Our Ref: AWE200083-L01: BCP/bcp
Contact: Dr Brett C. Phillips

22nd February 2021

RESPONSES TO FLOODING SUBMISSIONS, ASPECT INDUSTRIAL ESTATE, KEMPS CREEK, NSW

Figure 16 5 yr ARI Flood Velocities - Stage 1 Conditions

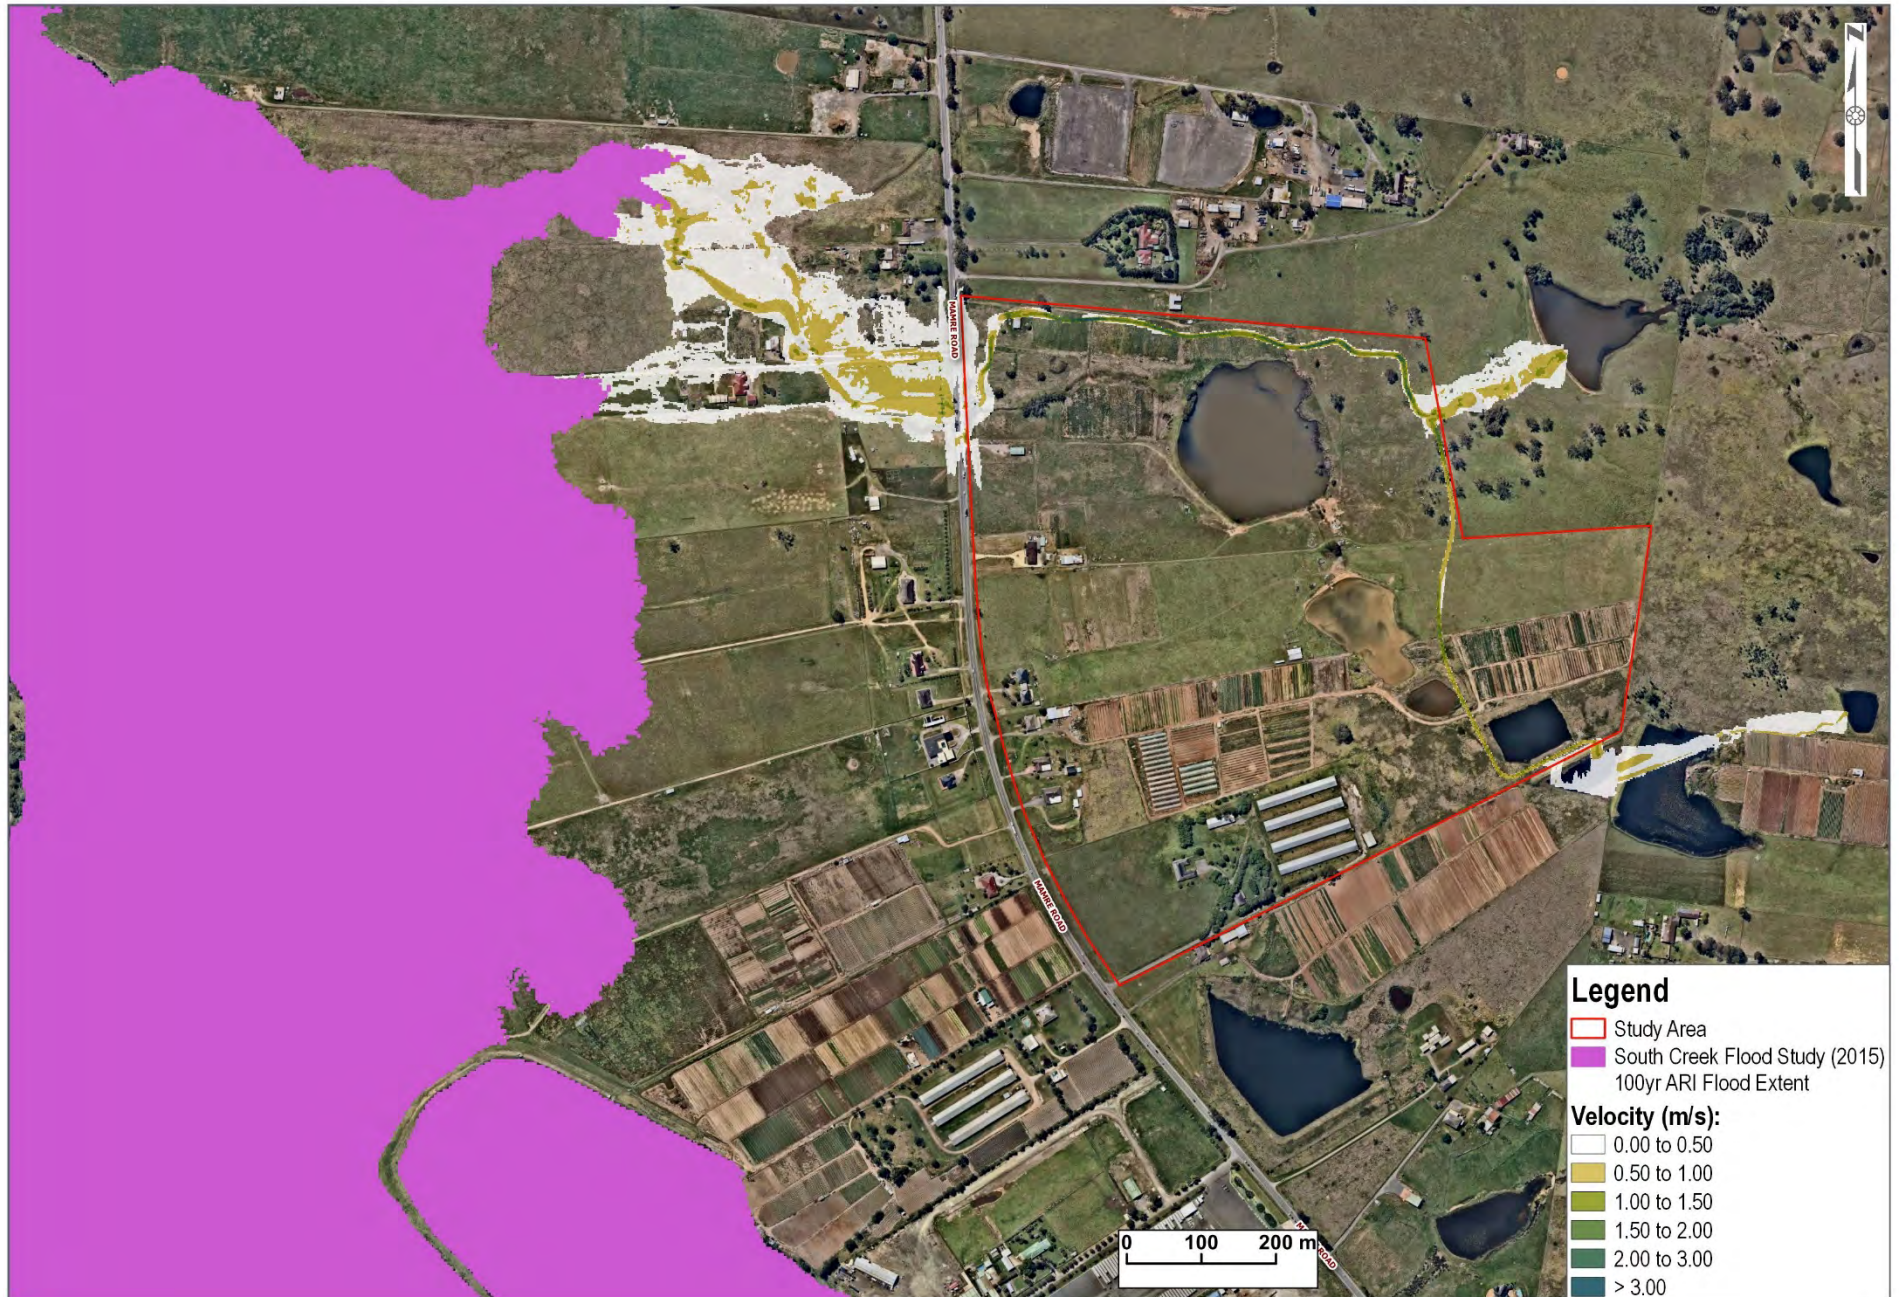
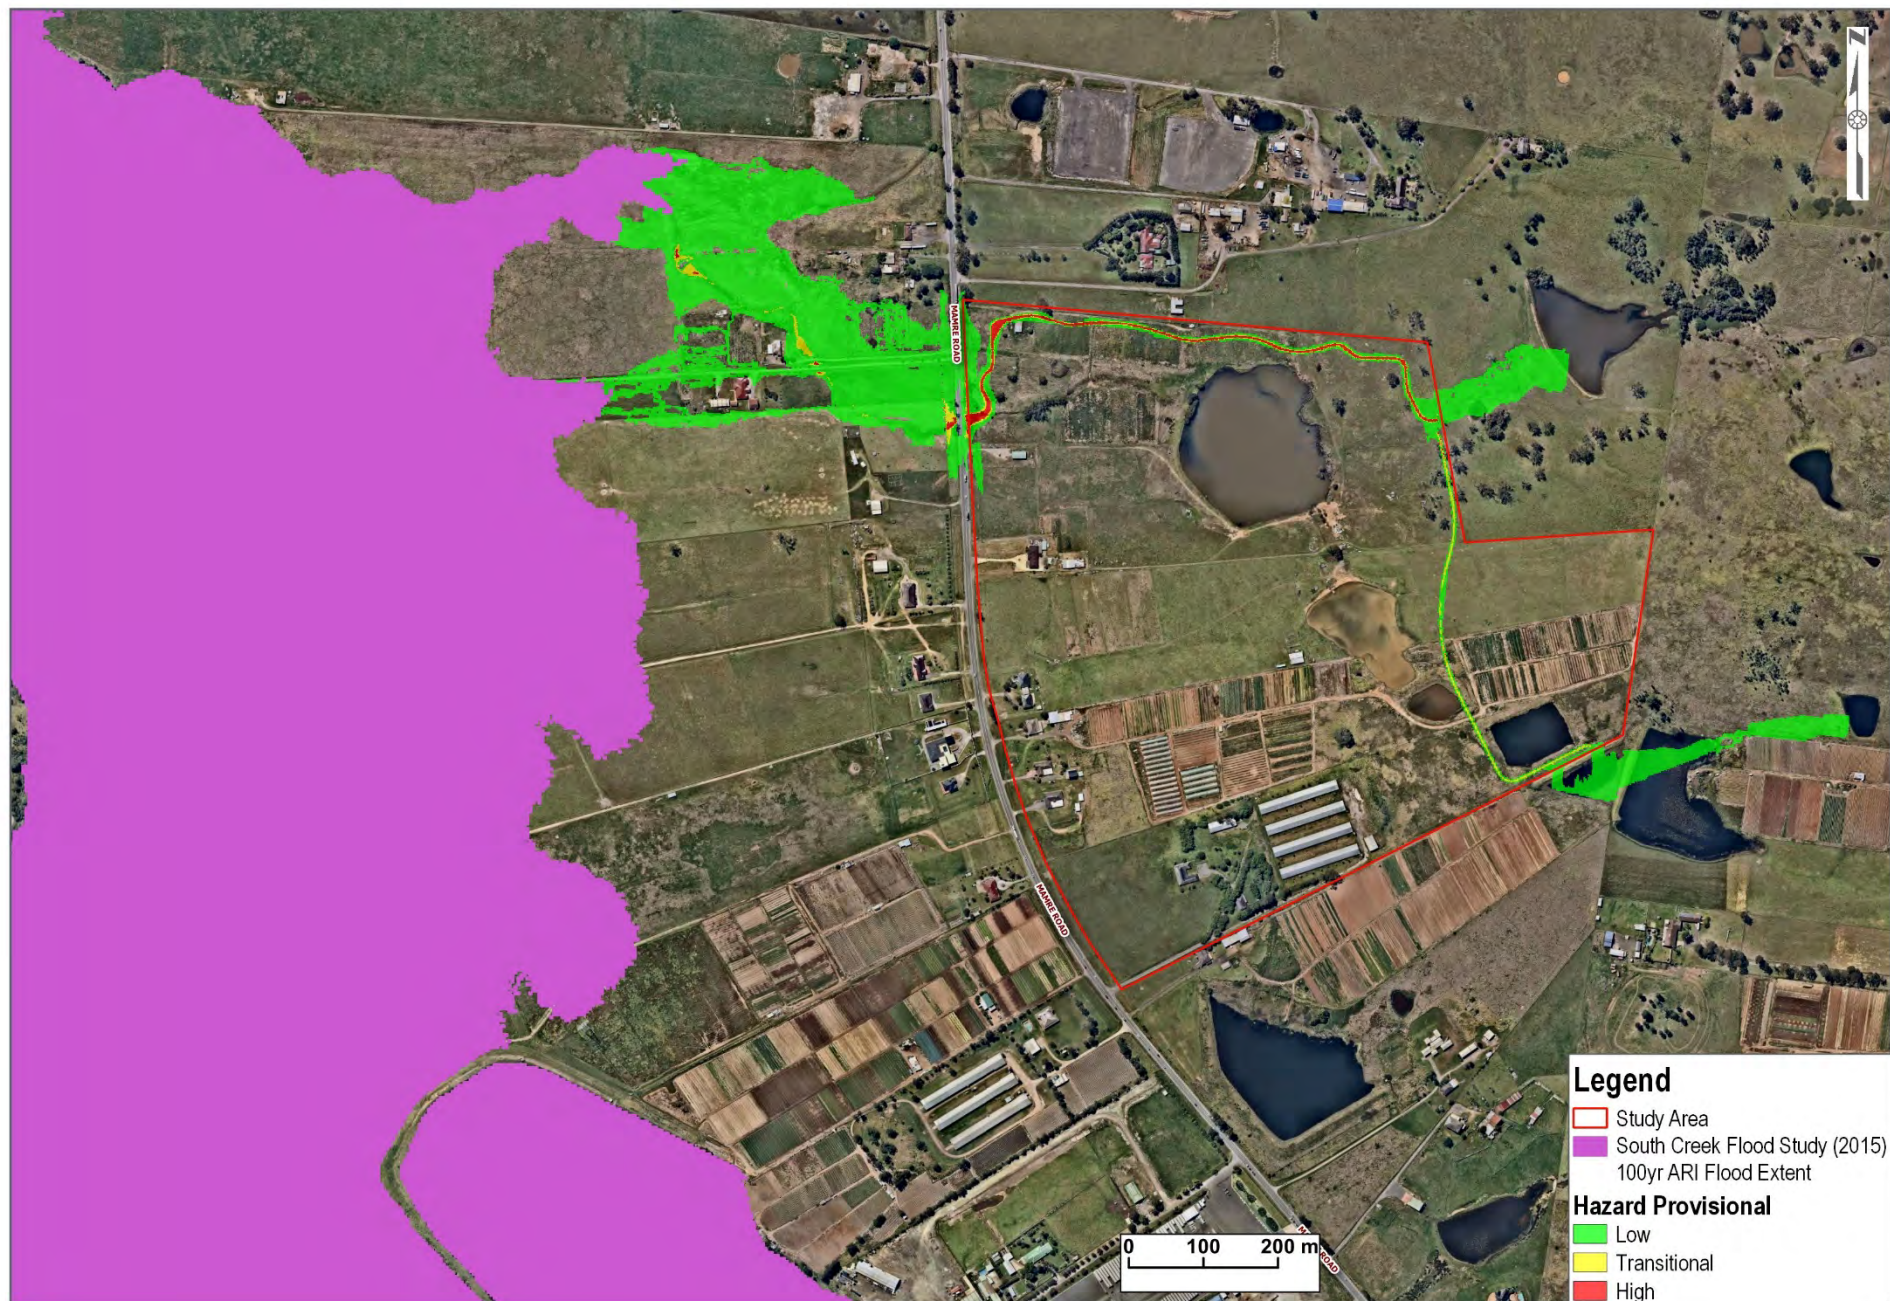
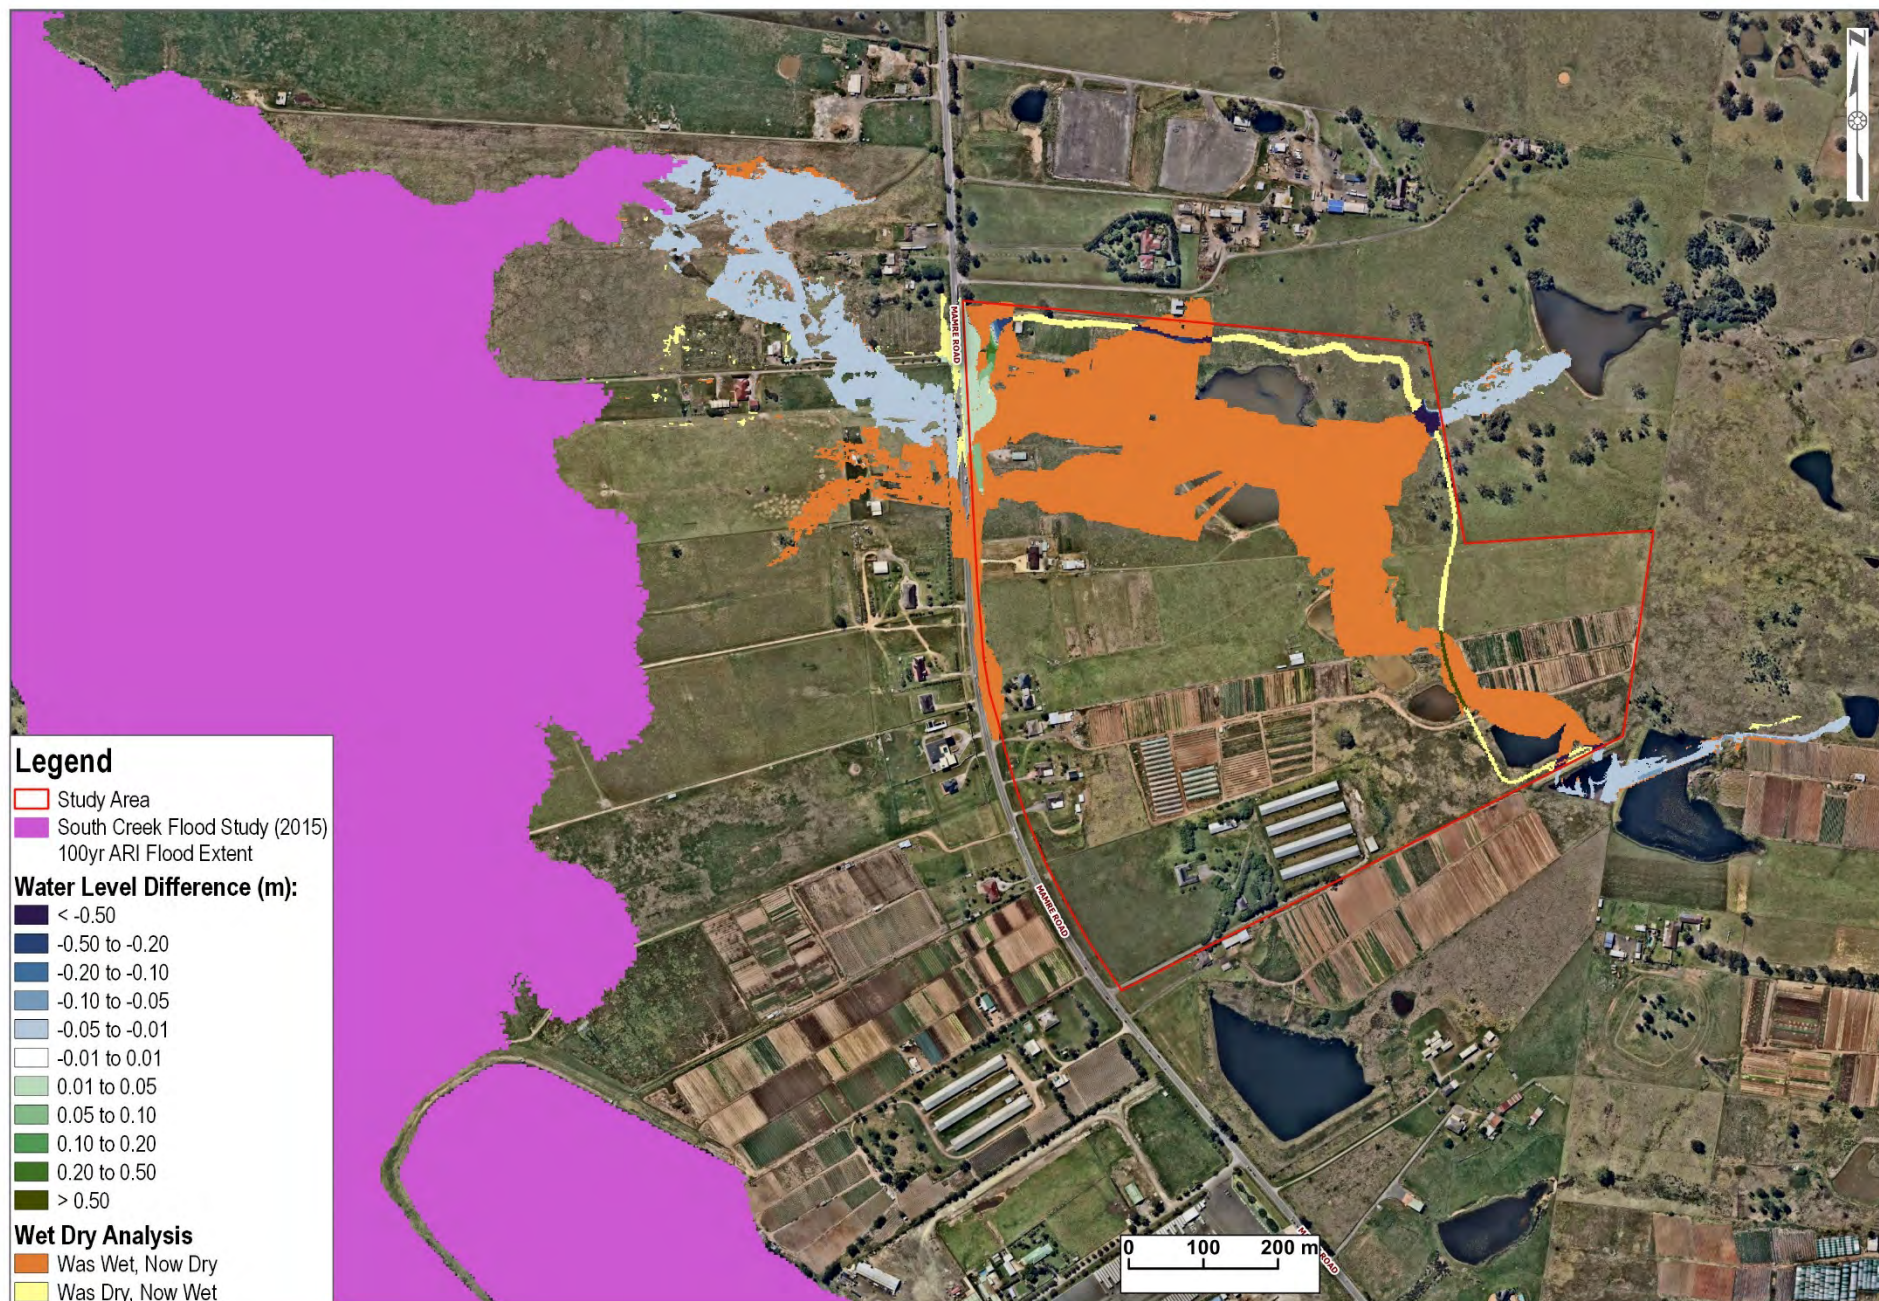
- *The developed scenario maps present local overland flow for Stage 1 which comprises of two industrial lots on the northern part of the site. However, from a flow management perspective, an overland flow study should consider the ultimate developed scenario of the site instead of considering each progressive development independently.*

- *All maps for developed conditions should properly depict the layout of the development, locations of proposed constructed channels and the location of the proposed detention basin.*

The final masterplan has been assessed and the results of the assessment have been incorporated into an updated version of the FIA report.

The updated Figures have been incorporated into an updated version of the FIA report.
